27 November 2018

**Altis Warehouse and Logistics Hub at 585-649 Mamre Road, Orchard Hills  
(SSD 7173 MOD 6) - Modification Application**

Council has reviewed the modification application and provides the following comments for consideration in the assessment of the application:

JOB TITLE PLAN OF PROPOSED SUBDIVISION OF LOT 8 DP271141 ERSKINE PARK			Plan No.: 73535.008 VER 7
Reduction Ratio: 1:3000	Date of Survey: N/A	Surveyor: GKO Drawn By: SHL	Sheet 2 of 2

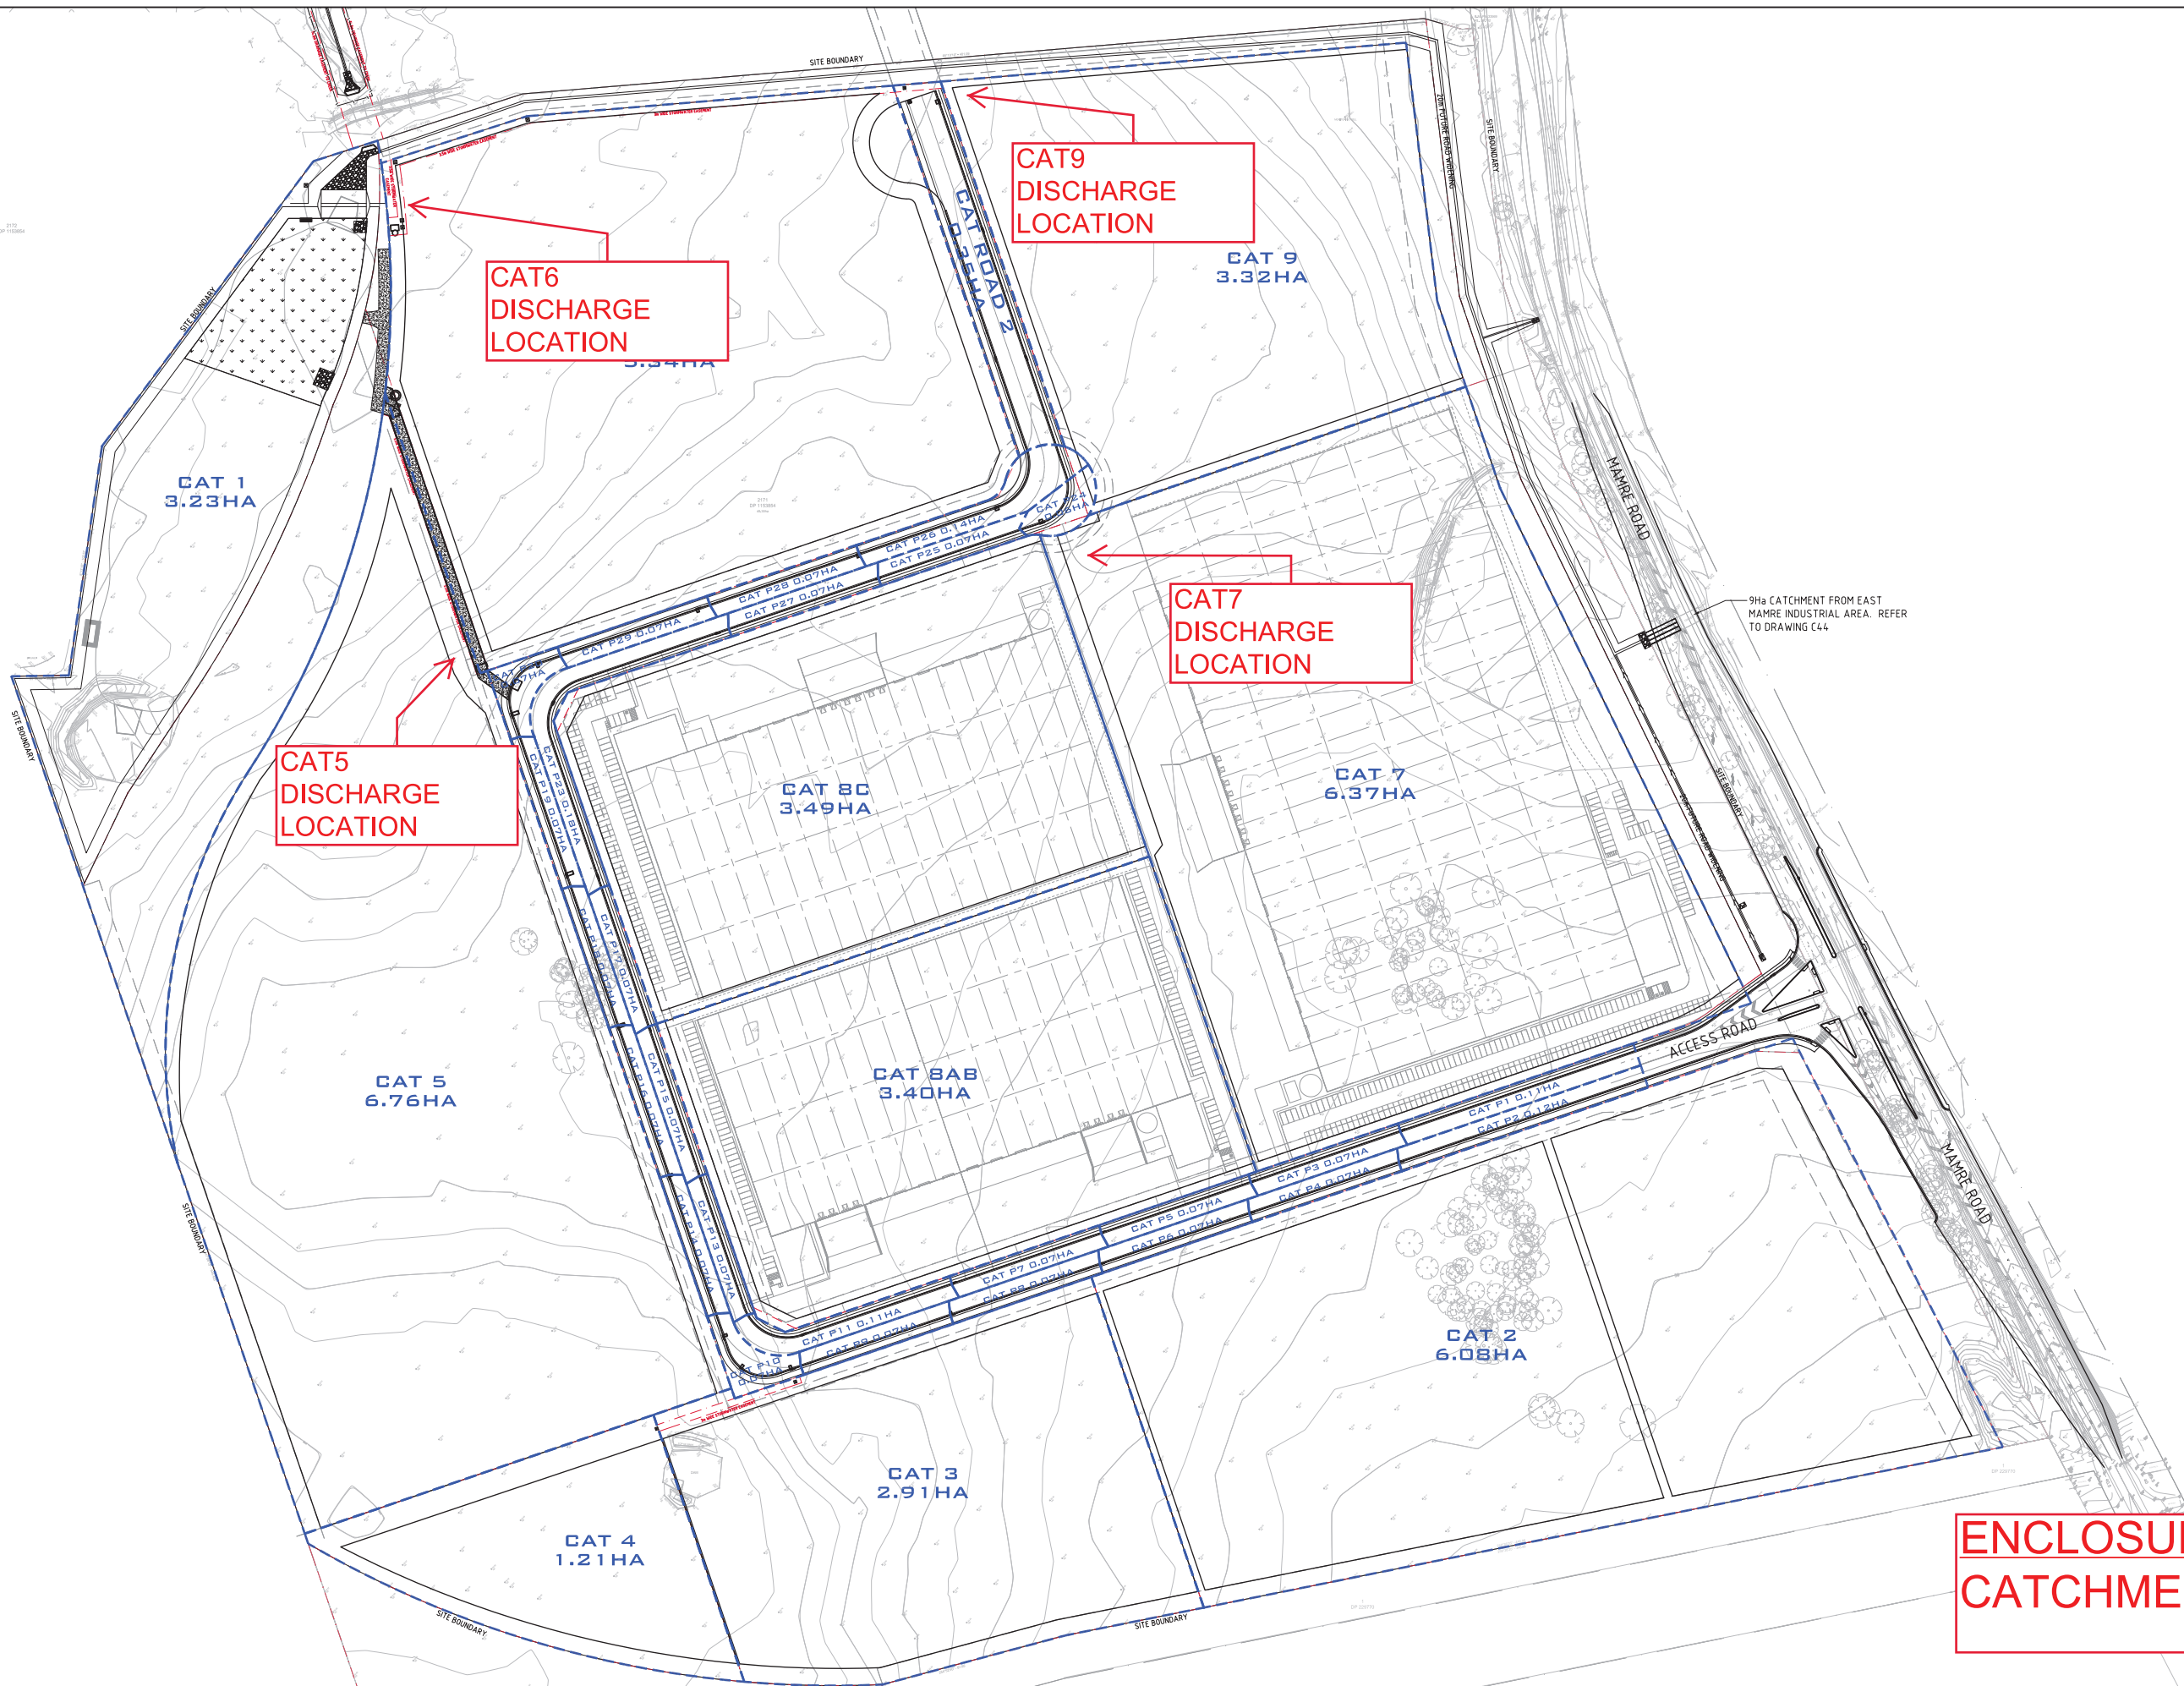
The proposed Civil & Stormwater Plans as submitted are not civil design drawings and appear to be a copy of subdivision plans with hand written drainage notes.

Detailed civil design drawings indicating all proposed drainage works with level notations and associated contours is required to be submitted to enable adequate assessment of the modification application in accordance with Council's 'Design Guidelines for Engineering Works for Submission and Developments'.
